2024/0058

Address: 2 Mayfield Court, Oxspring, Sheffield, S36 8YY

Description: Rear extension to single storey detached dwelling.

**PROPOSED SINGLE STOREY
REAR EXTENSION
2 MAYFIELD COURT
OXSPRING S36 8YY
SCALE 1:50 DRWG No P1**

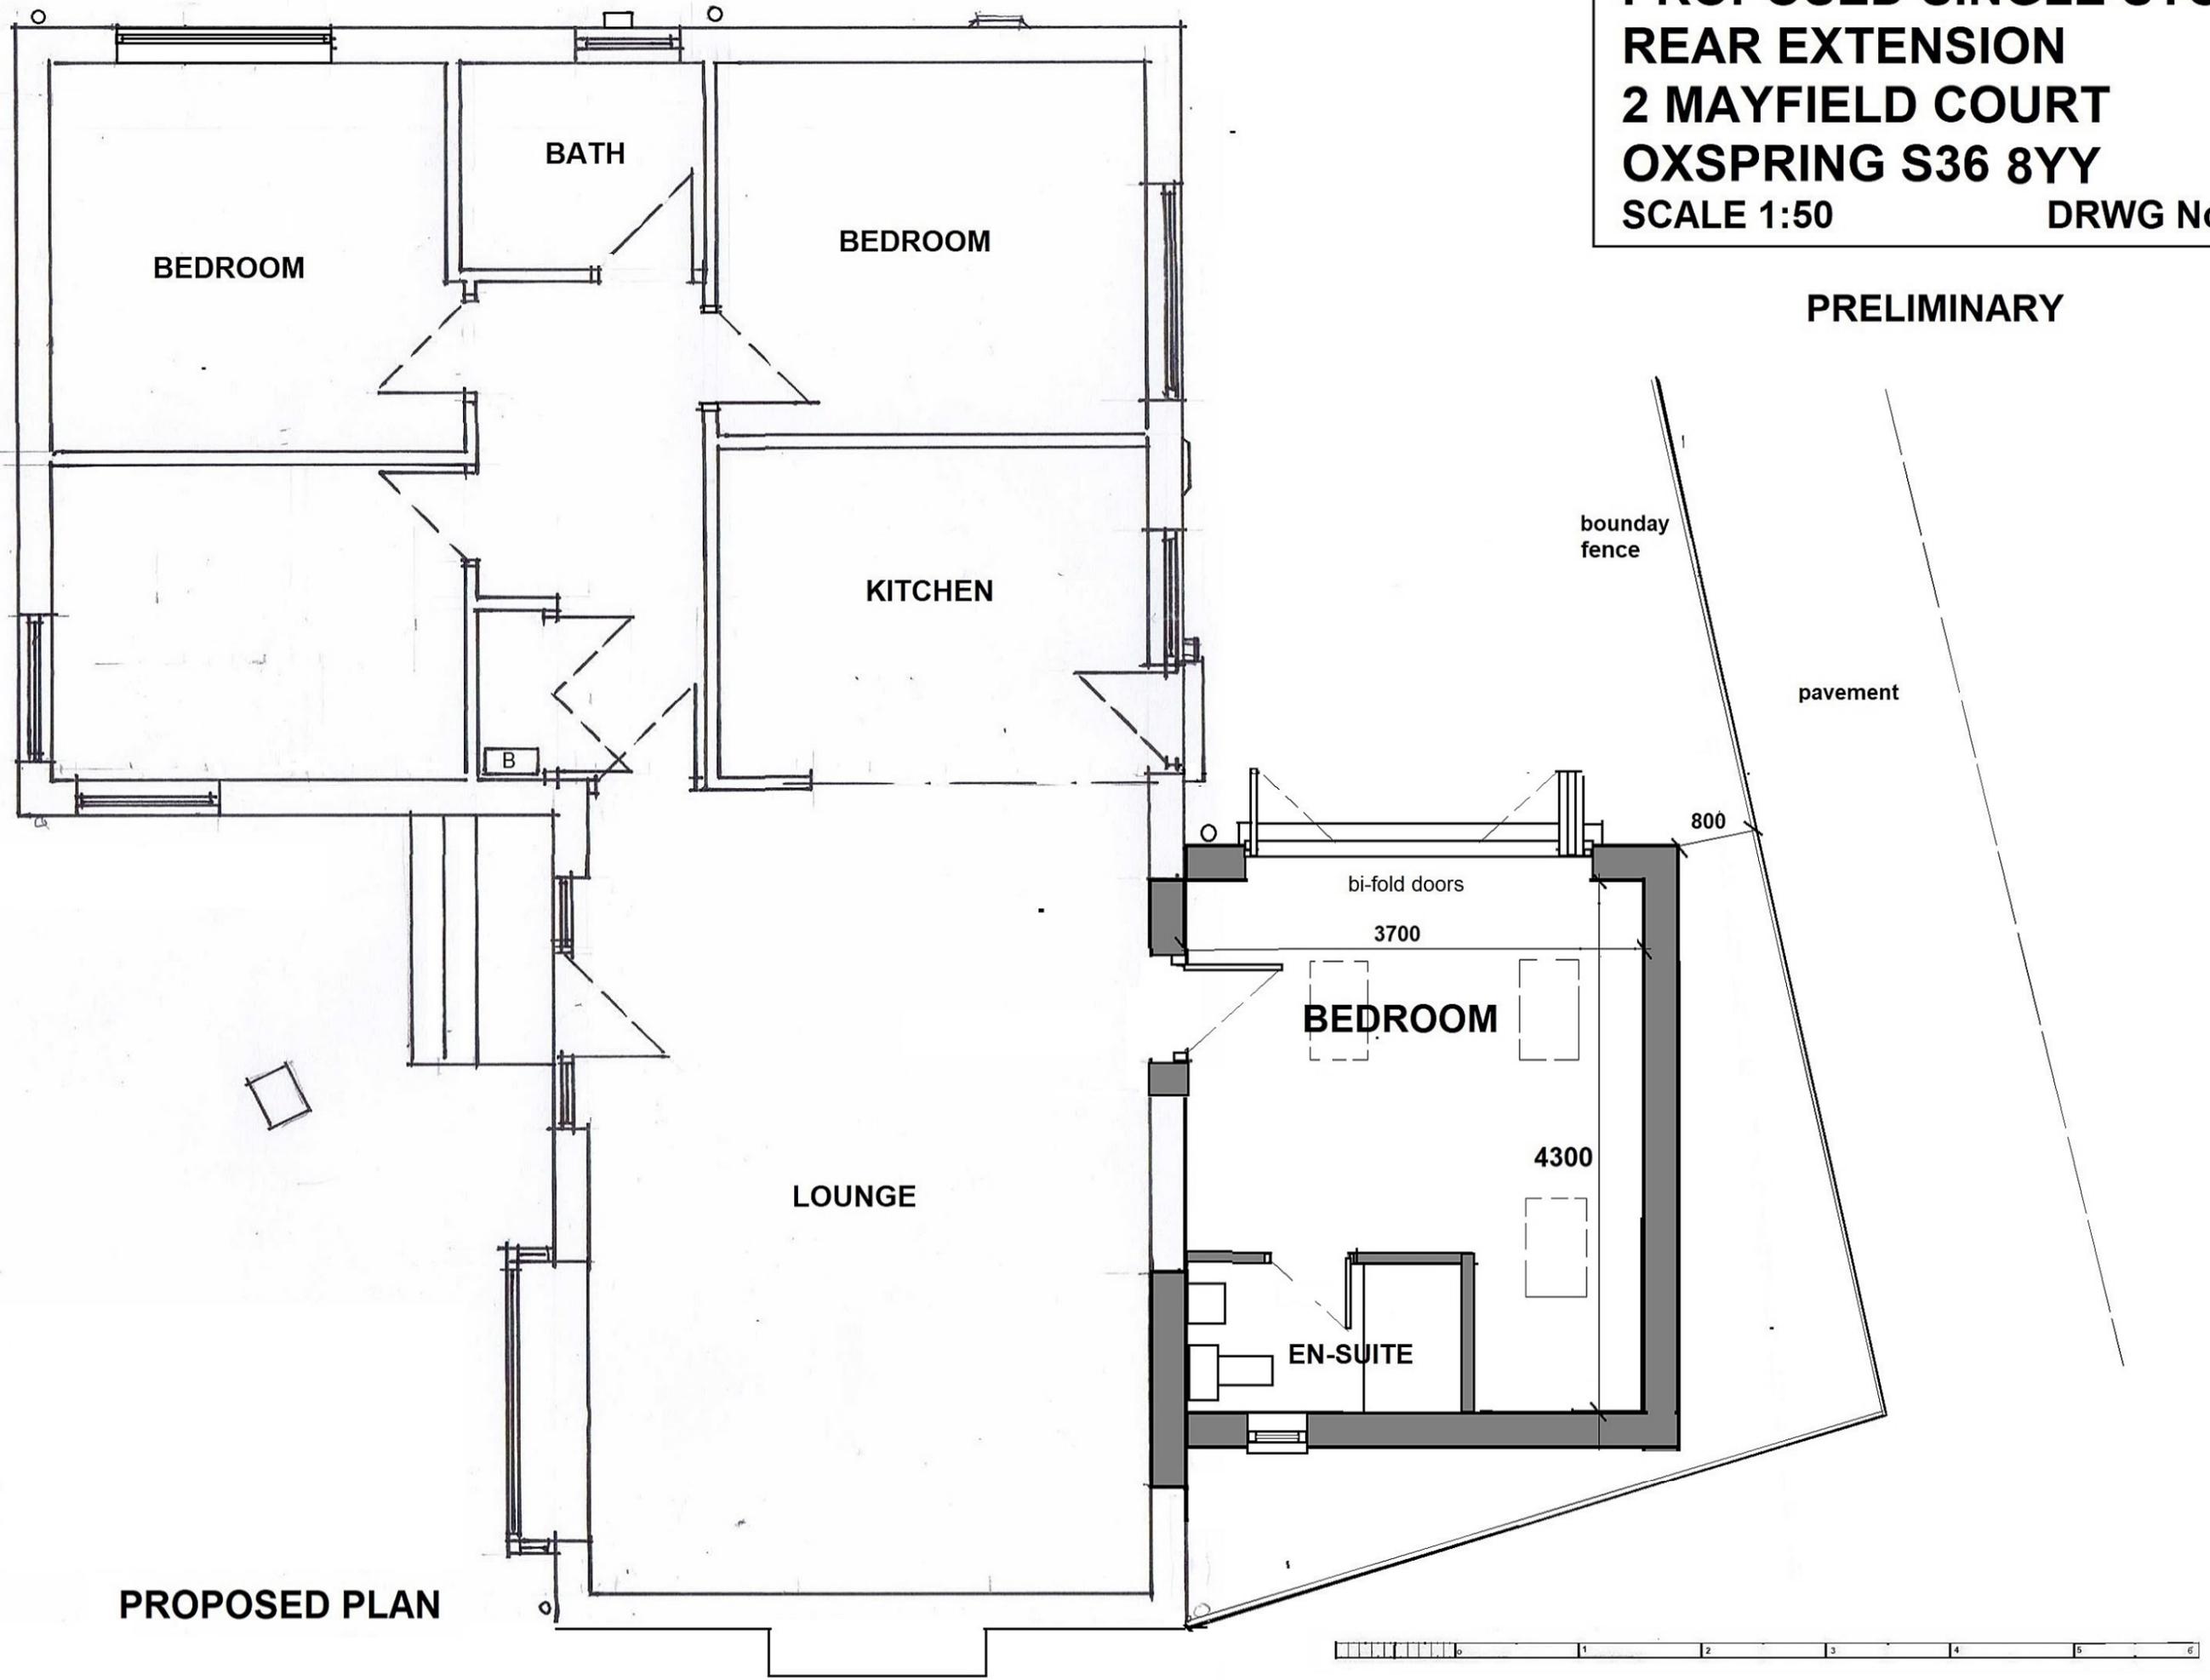
Parish Council: The parish council raised initial concerns about the location of the bi-fold doors on the original plan, and their impact upon the visual amenity of the street scene. The location of the doors has now been relocated to a less prominent position, with the elevation facing Mayfield looking more in keeping with the street scene.

**PROPOSED SINGLE STOREY
 REAR EXTENSION
 2 MAYFIELD COURT
 OXSPRING S36 8YY
 SCALE 1:100 DRWG No P2**

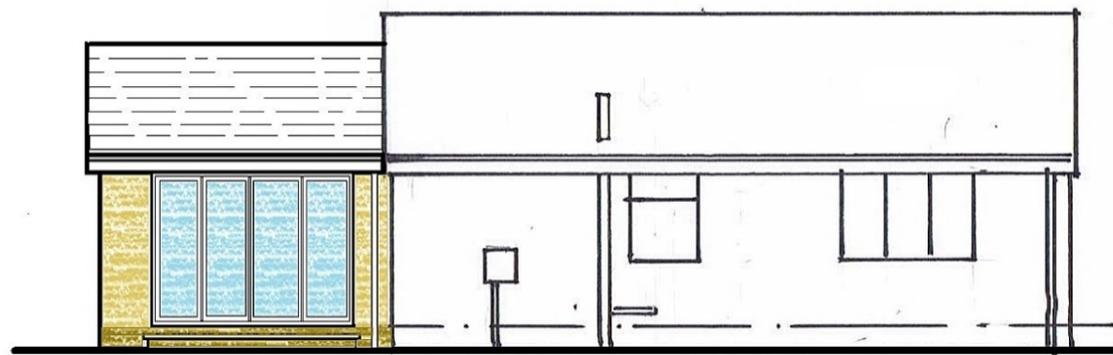
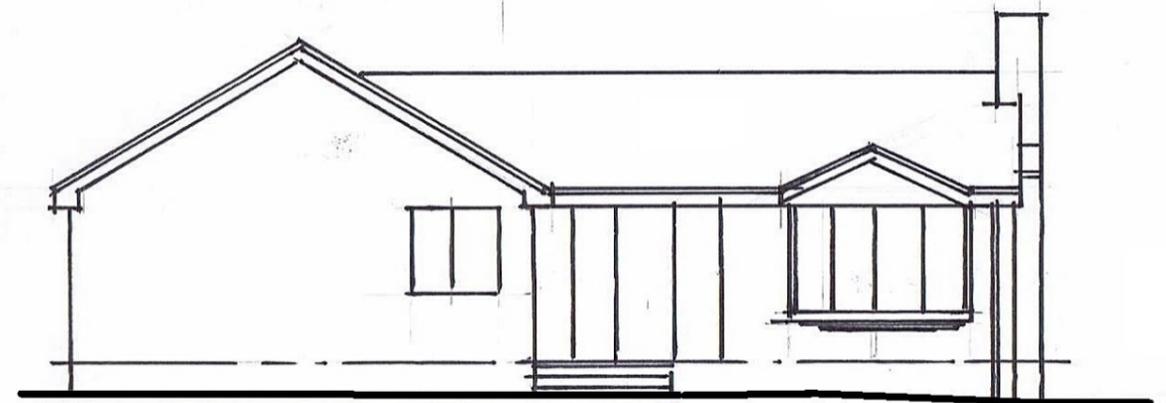
The dwelling and its curtilage are located within an unusual position, where the rear garden is a prominent feature of a different street scene (Mayfield) to that of the principal front elevation located on Mayfield Court. Whilst the original plans, through use of contrasting materials and glazed patio style doors in a prominent position, would have caused harm to the visual amenity of the street scene of Mayfield, and character of the dwelling; the final amended plans provide an acceptable balance of the desire for the homeowner to have an extension within their rear garden, whilst overall respecting the broader street scene of Mayfield, and ultimately Mayfield Court. Whilst bifold doors are not an ideal feature within an average street scene, their location is now in a less prominent location than originally proposed, with a matching size and style window on the formerly proposed blank elevation, to that of an existing window on the same elevation. With matching materials proposed, this also helps retain the character of the dwelling and its position within the broader street scene.
